Brethren Frontier School Conditional Use Permit (CU-22-00003)

TO: Kittitas County Hearing Examiner
FROM: Kelly Bacon, Staff Planner
RE: Calvary Ellensburg Conditional Use Permit (CU-22-00002)
DATE: November 22, 2022

1061 EMERSON RD
PROPOSED MULTI PURPOSE BLDG
1" = 10'

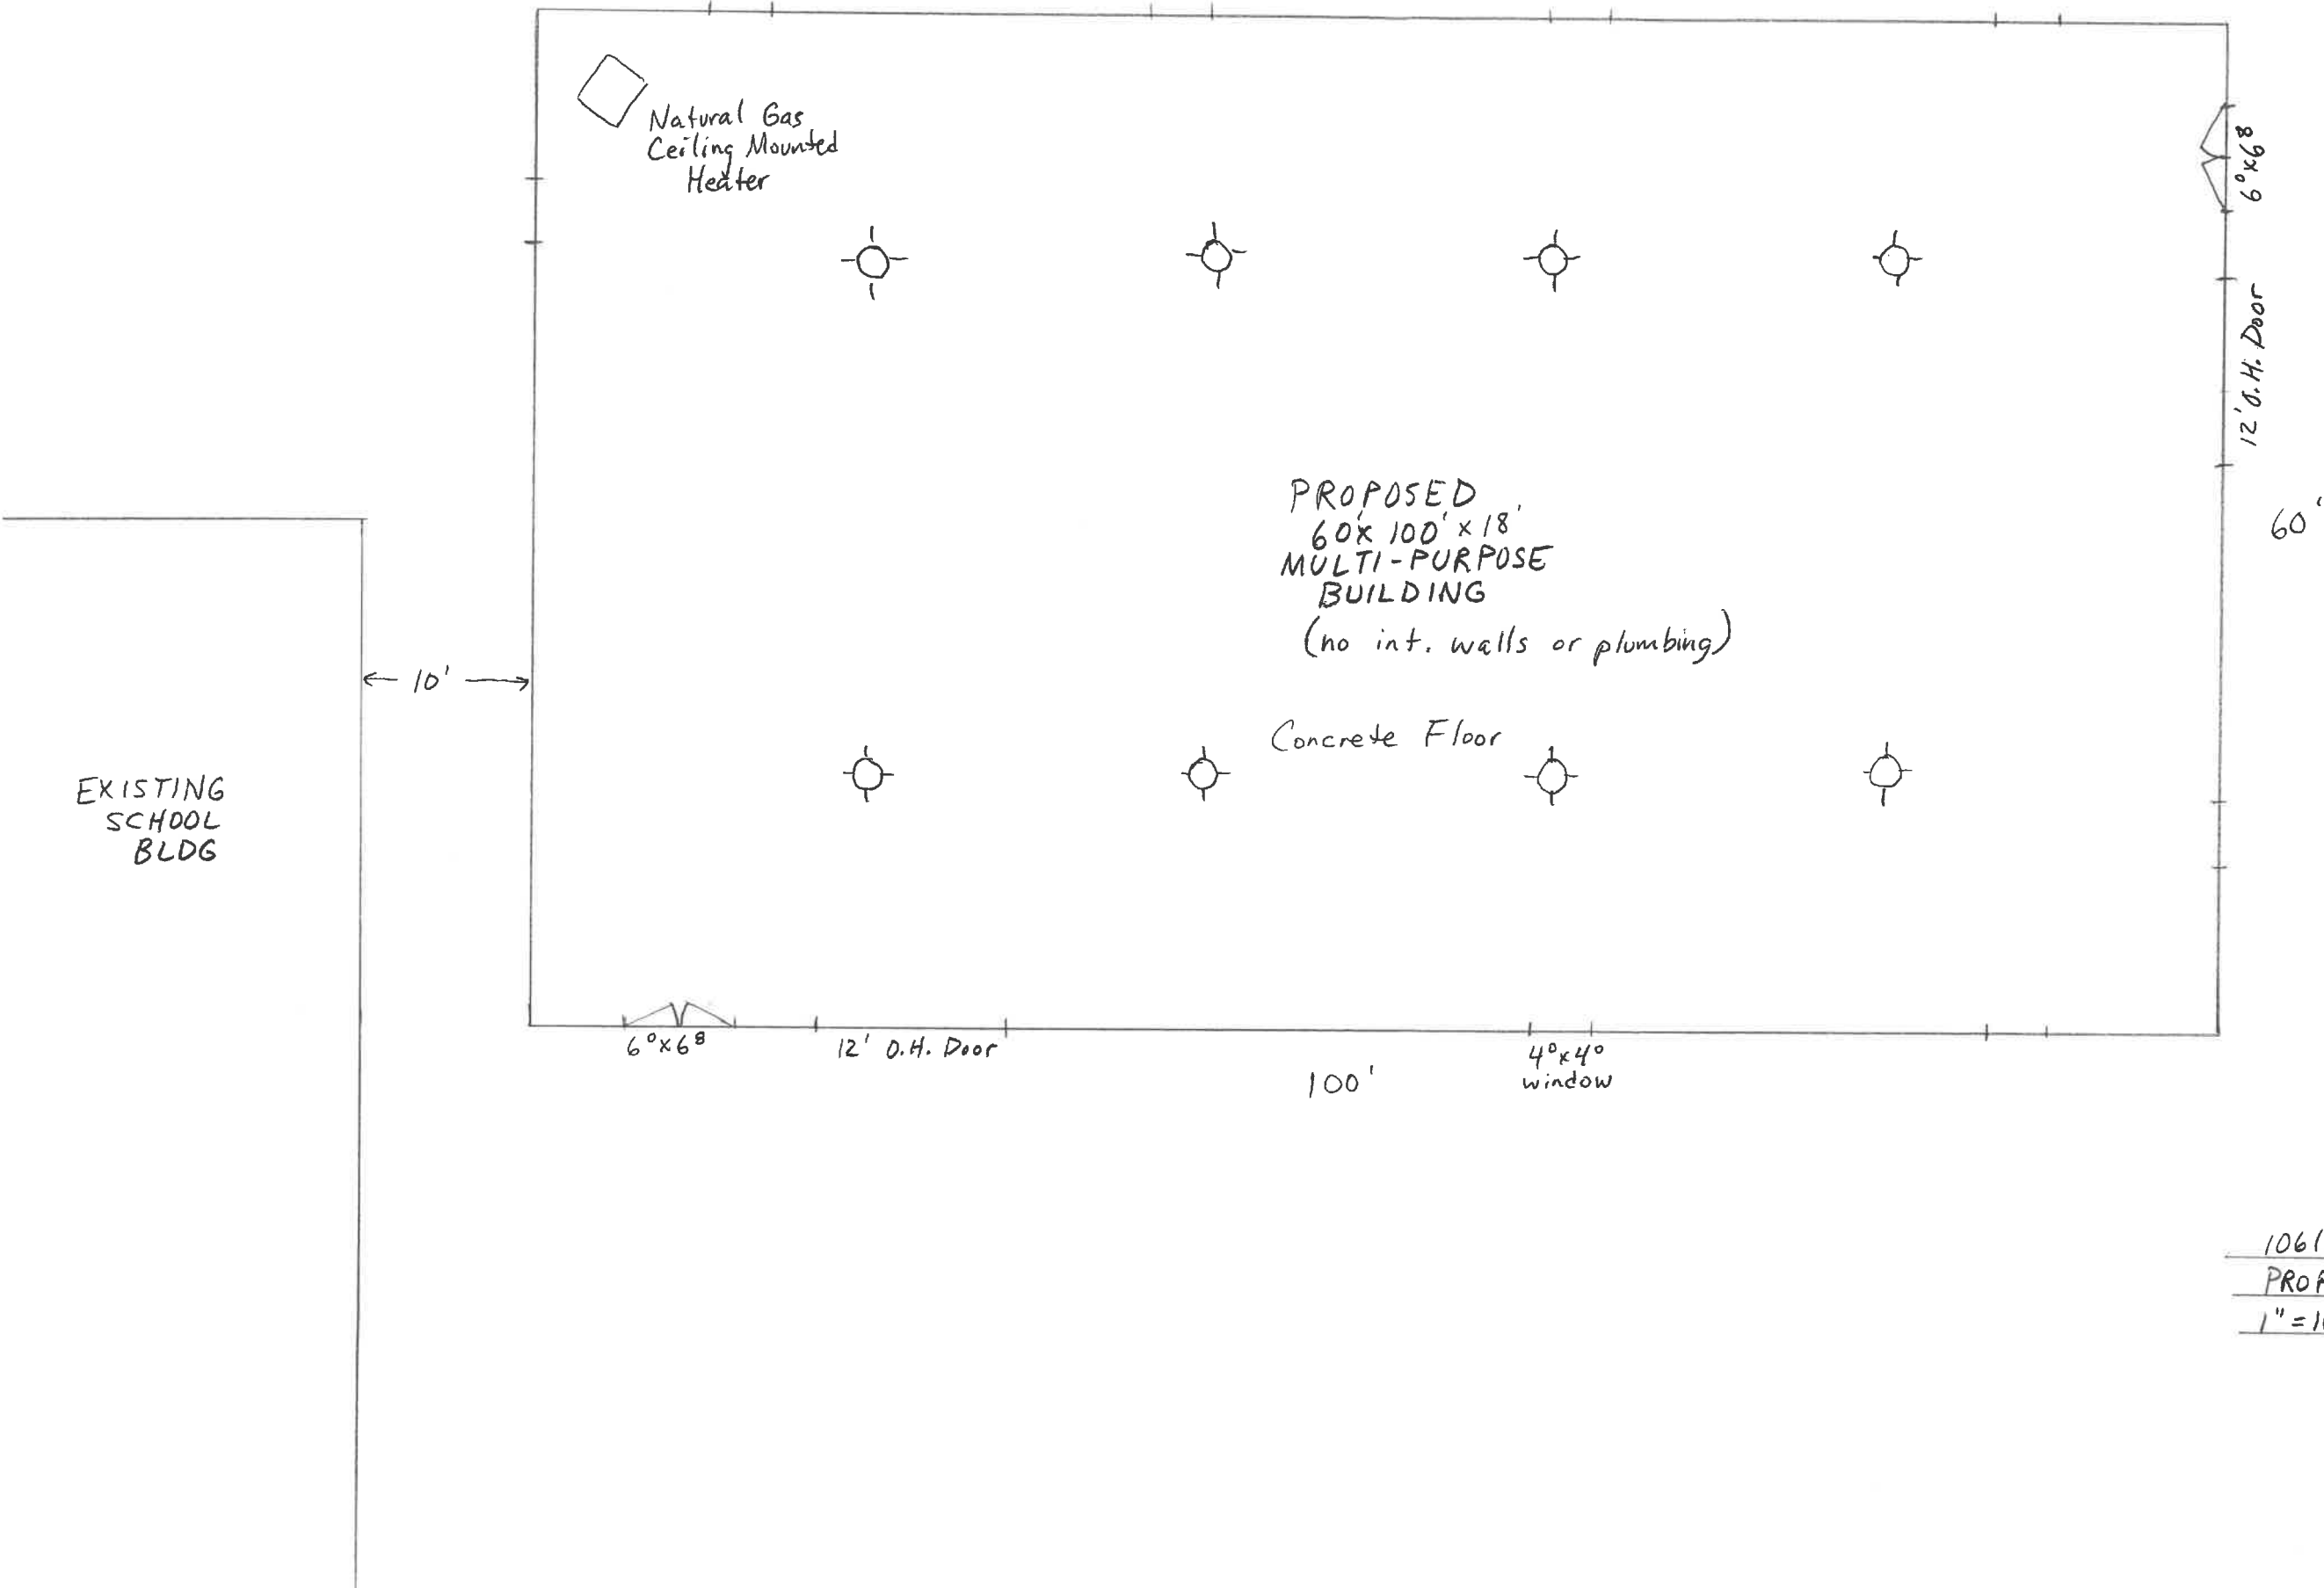
Kittitas County Public Health commented that the applicant must provide current, satisfactory bacteriological and nitrate test results on the water system to Kittitas County Public Health and that the proposed site plan appears to

have the driveway and possibly parking going over the current drainfield and asked that the applicants address the issue prior to moving forward with the project. (see Index #15)

1. The project shall proceed in substantial conformance with the plans and application materials on file with CDS dated July 21, 2022 and subsequent information included in the complete file index except as amended by the conditions herein.
2. The applicant shall comply with all Local, State and Federal environmental standards and regulations.
3. The applicant must provide current, satisfactory bacteriological and nitrate test results on the water system to the Kittitas County Public Health Department prior to use of either structure for school purposes.
4. The applicant shall install fencing or a rock barrier in conformance with the Amended Site Plan to

ensure the current drainfield for the school is not being driven over or parked on.
